**Recommendation Report for Planning Permission**

**REF NO:** P/28/13/

**LOCATION:** 14 Churchill Walk  
The Parade  
Pagham

**PROPOSAL:** Dwelling house and parking space (resubmission following P/33/12/)

proposed dwelling adj 14 Churchill Walk PAGHAM for Mr F Elliott	
plans, elevations & site layout	
PLAN NO	642/2
SCALES	1:100 1:50 1:500
DATE	03-13
DAVID J BROOKWELL 99 WESTMINSTER DRIVE BOGNOR REGIS PO21 3RG tel no 01243 264928

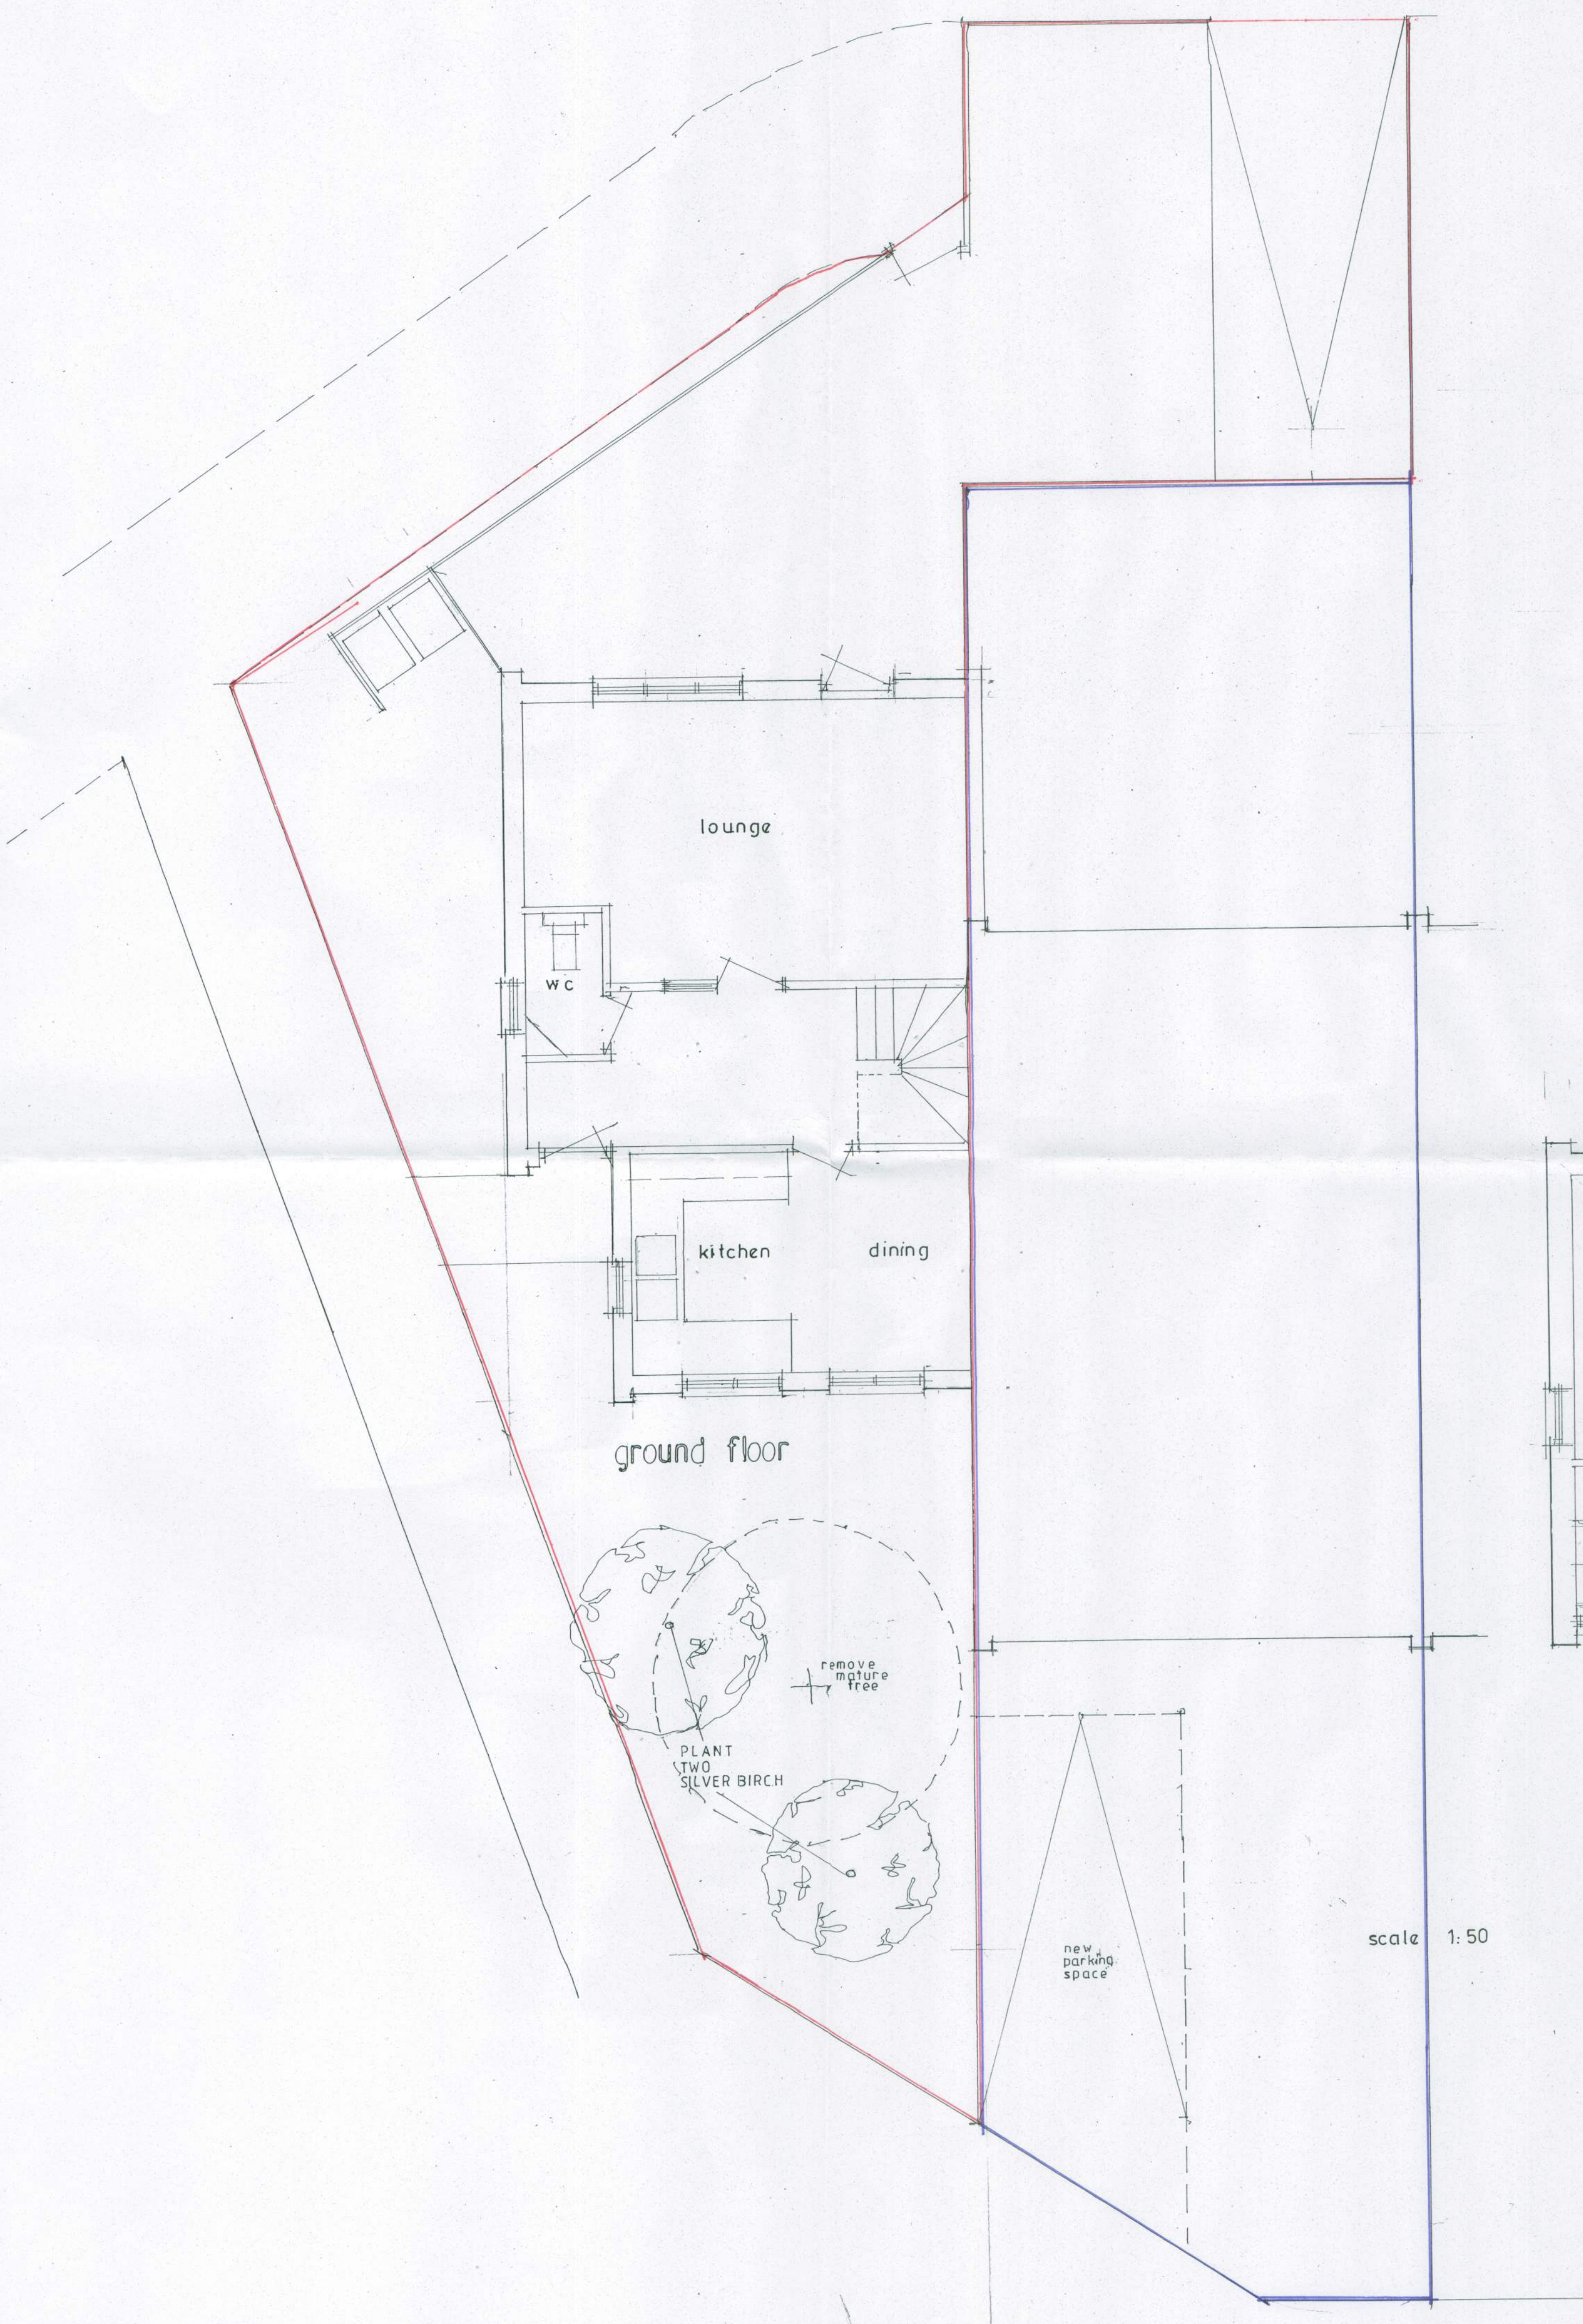
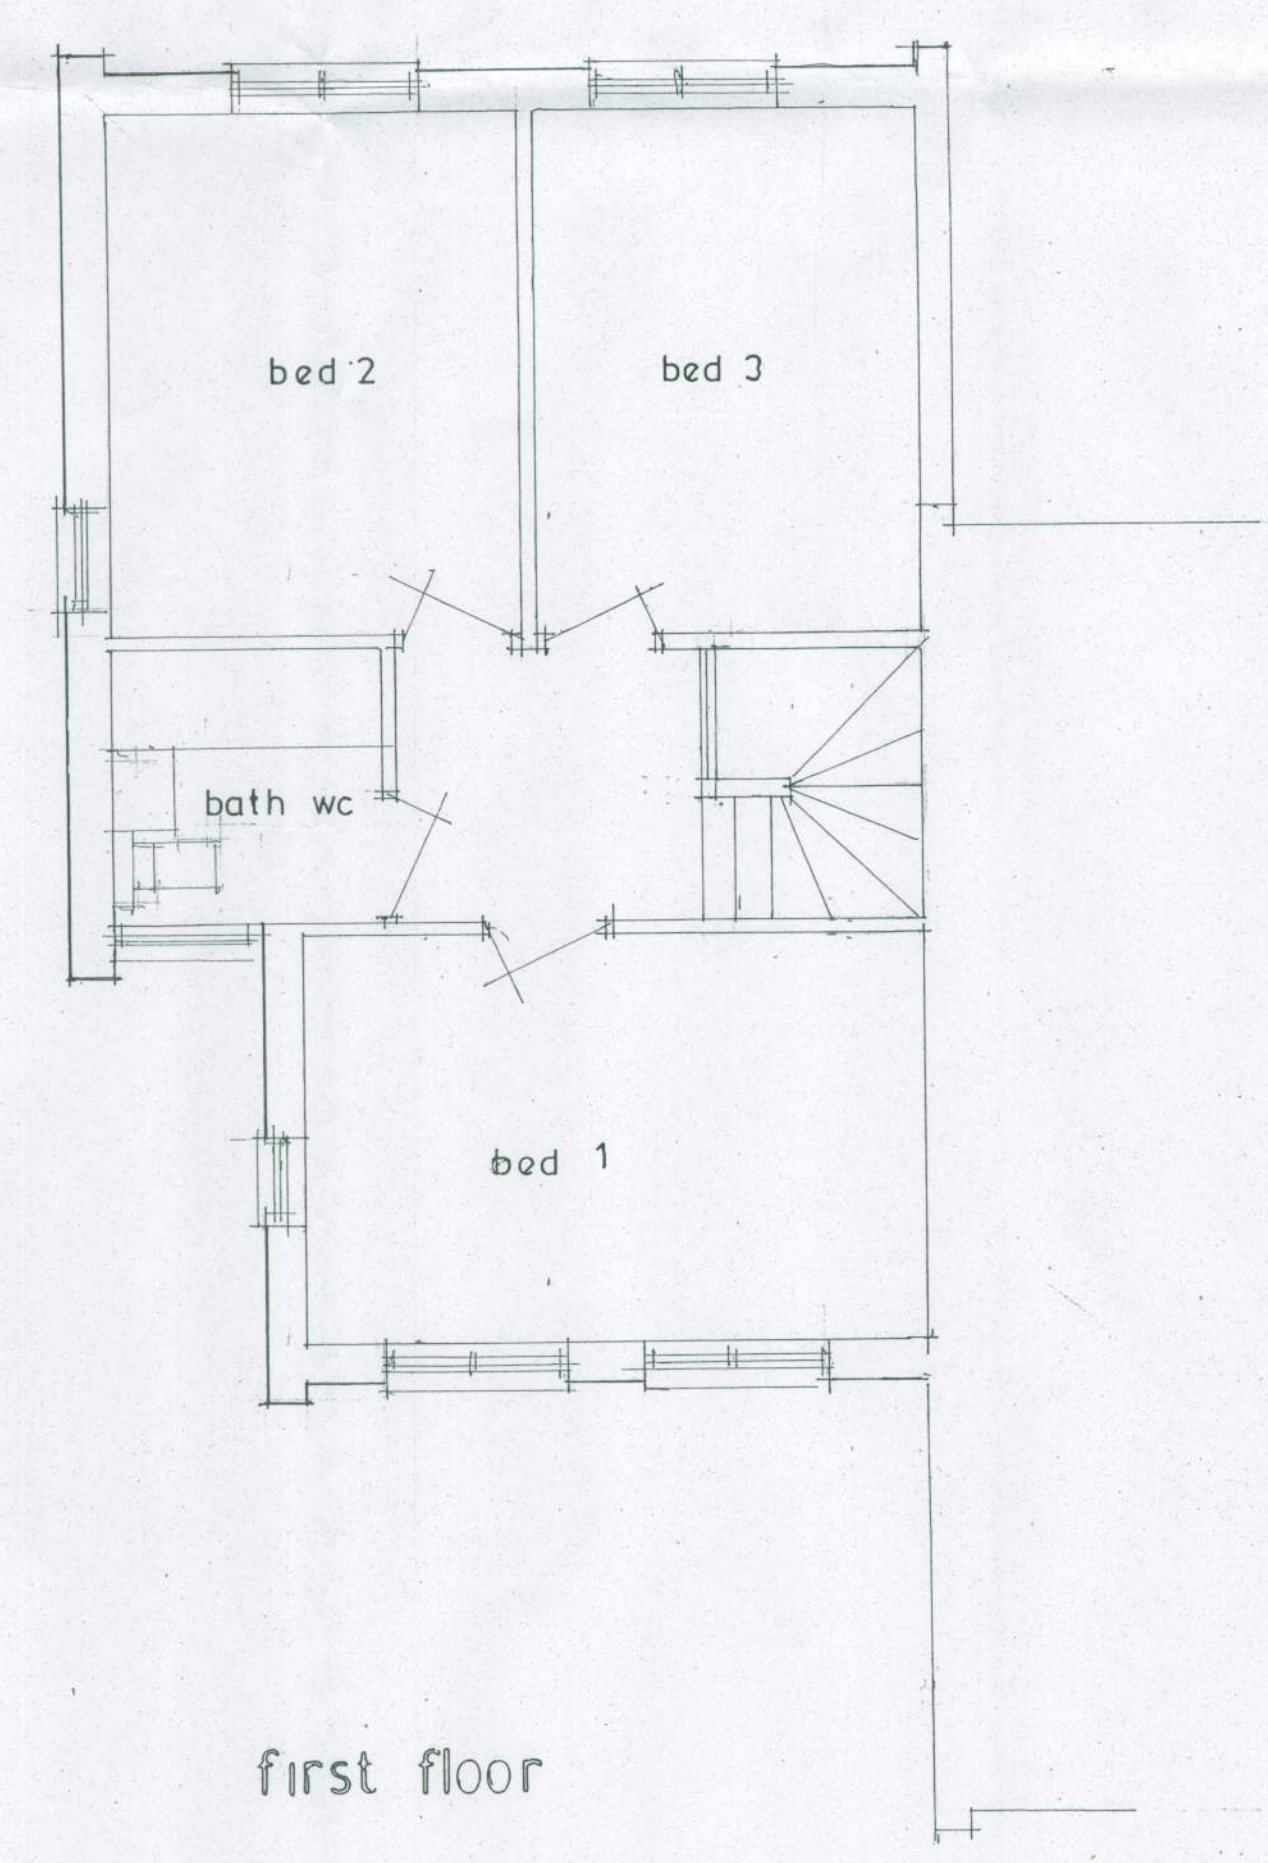
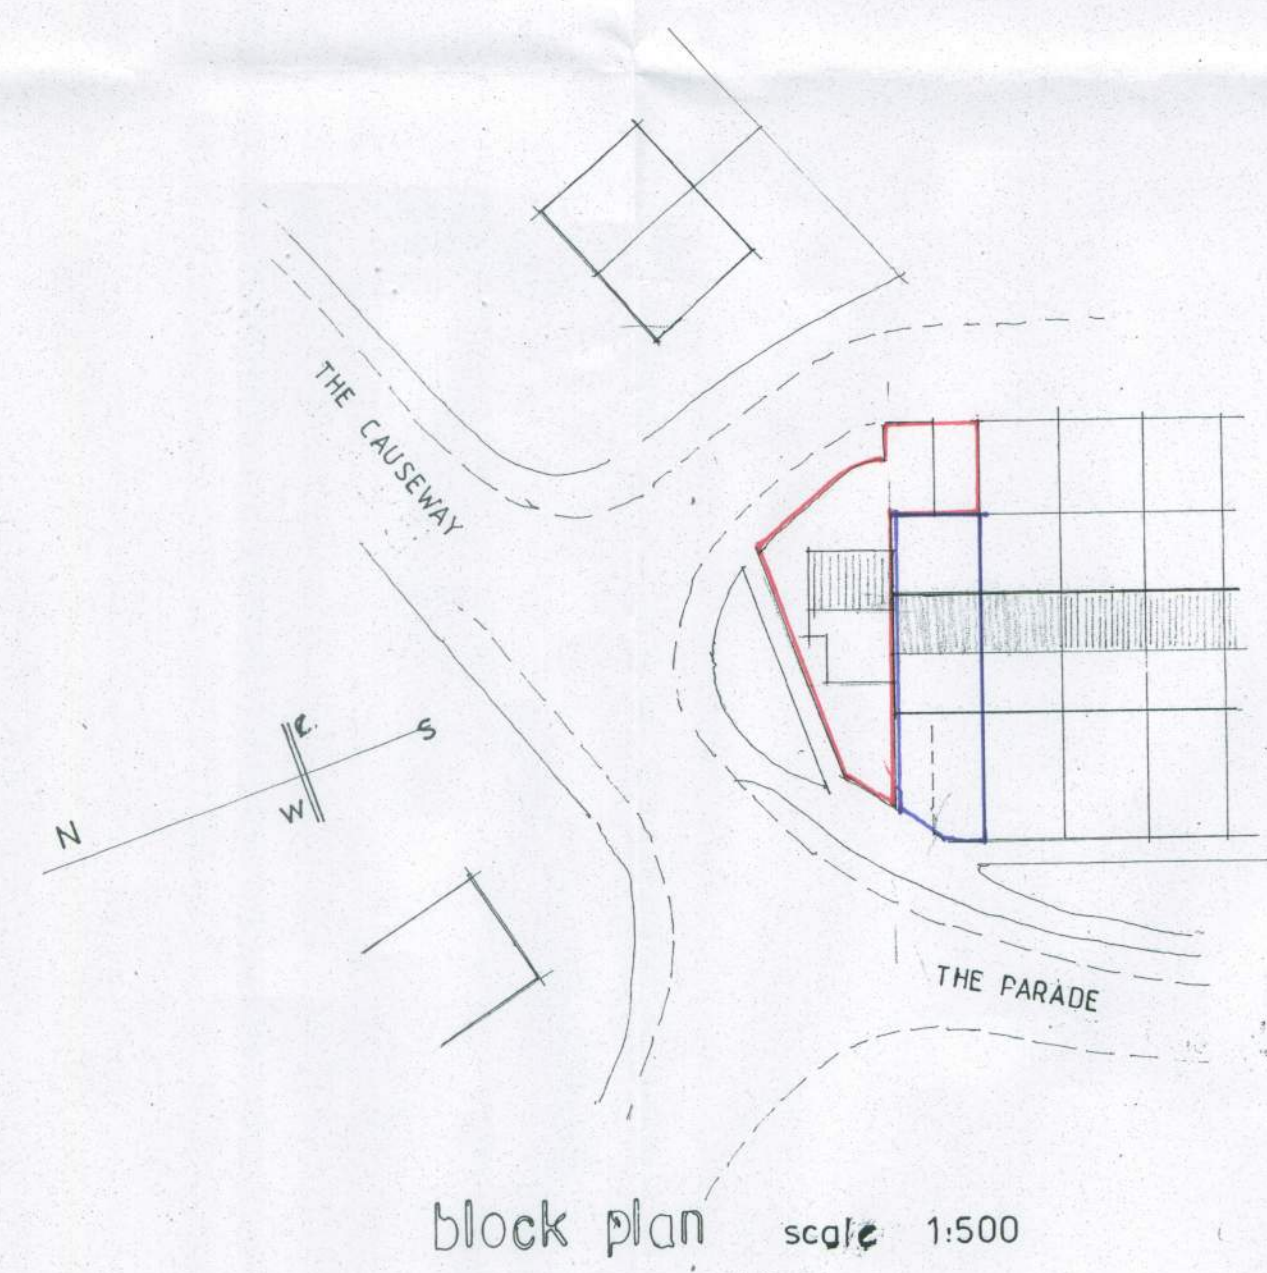
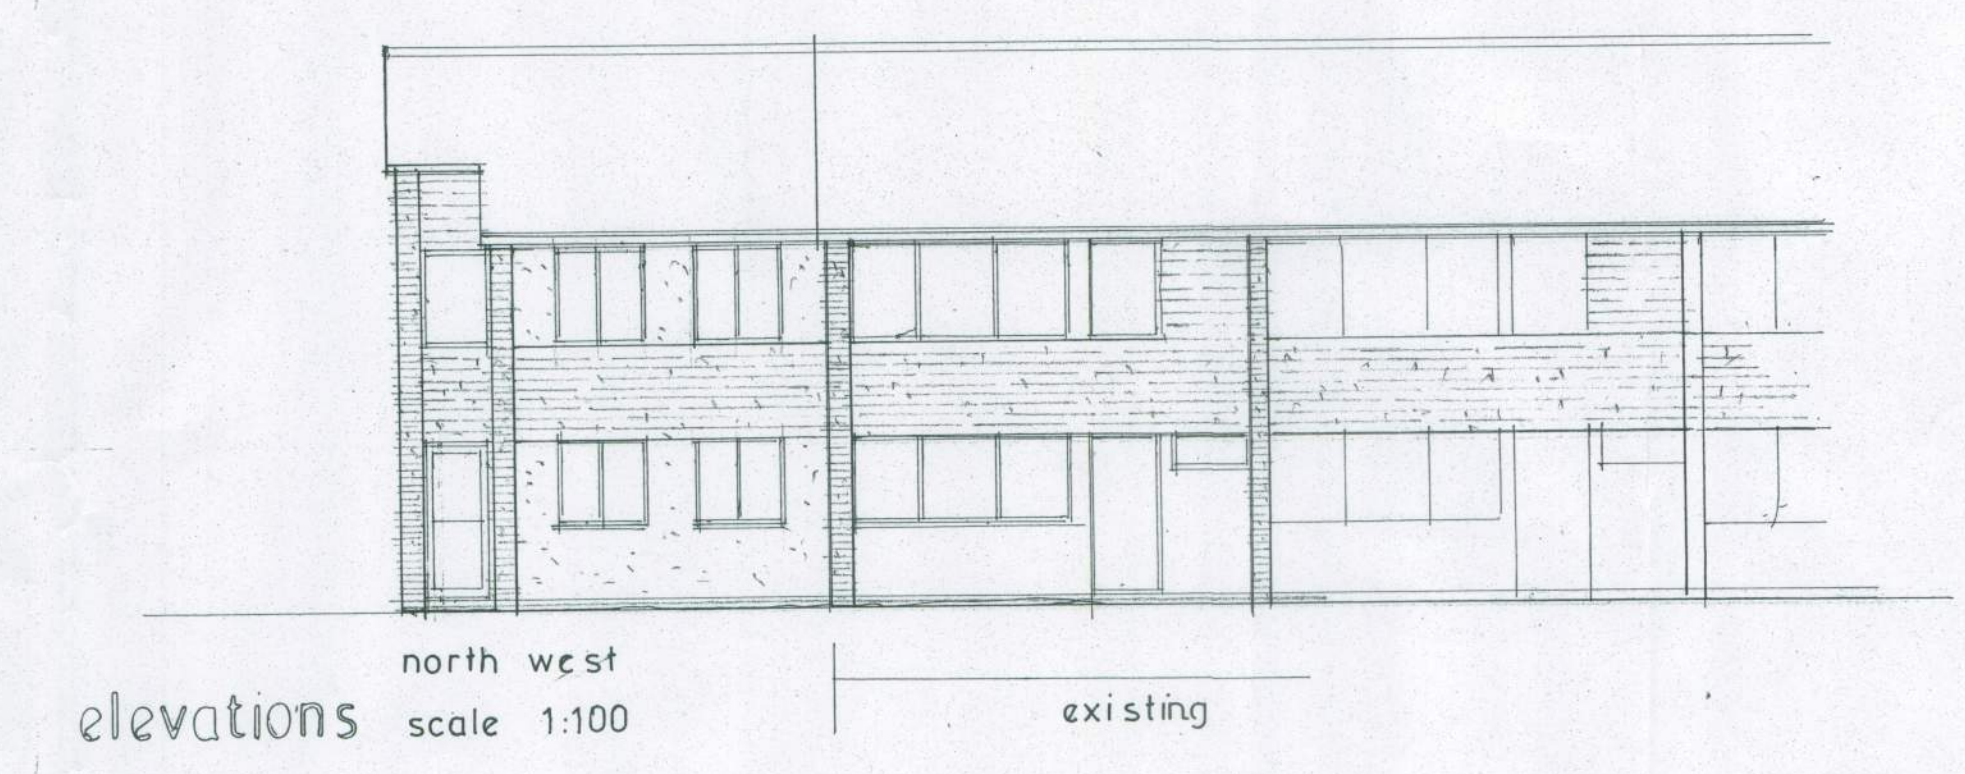
The proposal is considered to conflict with relevant Development Plan policies in that by reason of its siting and cramped space it does not contribute to the open and planned characteristics of the surrounding area. It would also give rise to a loss of outlook and daylight to the neighbouring property No 14.

The proposal now seeks to demolish the existing garage currently serving No 14 Churchill Walk and incorporate this space into the site with the construction of an attached two storey dwelling on the end of No 14 in the side garden. A new parking space will be provided at the front of the host dwelling No 14. The proposed dwelling will be set back from the front of the dwelling by approximately 3m and will at its lowest point leave a 1.1m gap to the public footway. It will be of the same height as the existing terrace and similar in appearance. By reason of its siting the proposed dwelling will project out from the host dwelling No 14 to the rear by 3m. No 14 has windows which serve the living area adjacent to the side flank wall of the dwelling and it is considered that this would seriously affect the occupants outlook and daylight.

The National Planning Policy Framework Paragraphs 56 and 57 specify good design that would achieve development that is better integrated with its surroundings. The plot is still considered to be of a size that would not easily accommodate a dwelling of this size and would afford a poor standard of amenity and outlook for future occupiers. It would erode the open spacious character and appearance of the area which is a feature of the 1960's estate.

It is considered that the proposed development by reason of its prominent siting would appear incongruous in the street scene and harm the open and spacious character of the area.

- 1 The proposal is sited within an inadequately sized plot which is uncharacteristically small to accommodate a dwelling and would appear as a cramped form of development which is harmful to the open and planned characteristics of the surrounding area in conflict with policy GEN7 of the Arun District Local Plan and the National Planning Policy Framework.
- 2 The proposal by reason of its siting and relationship with the neighbouring dwelling (No 14) would be overbearing and unneighbourly giving rise to a loss of outlook and daylight in conflict with policy GEN7 of the Arun District Local Plan, the National Planning Policy Framework and the Pagham Village Design Statement.
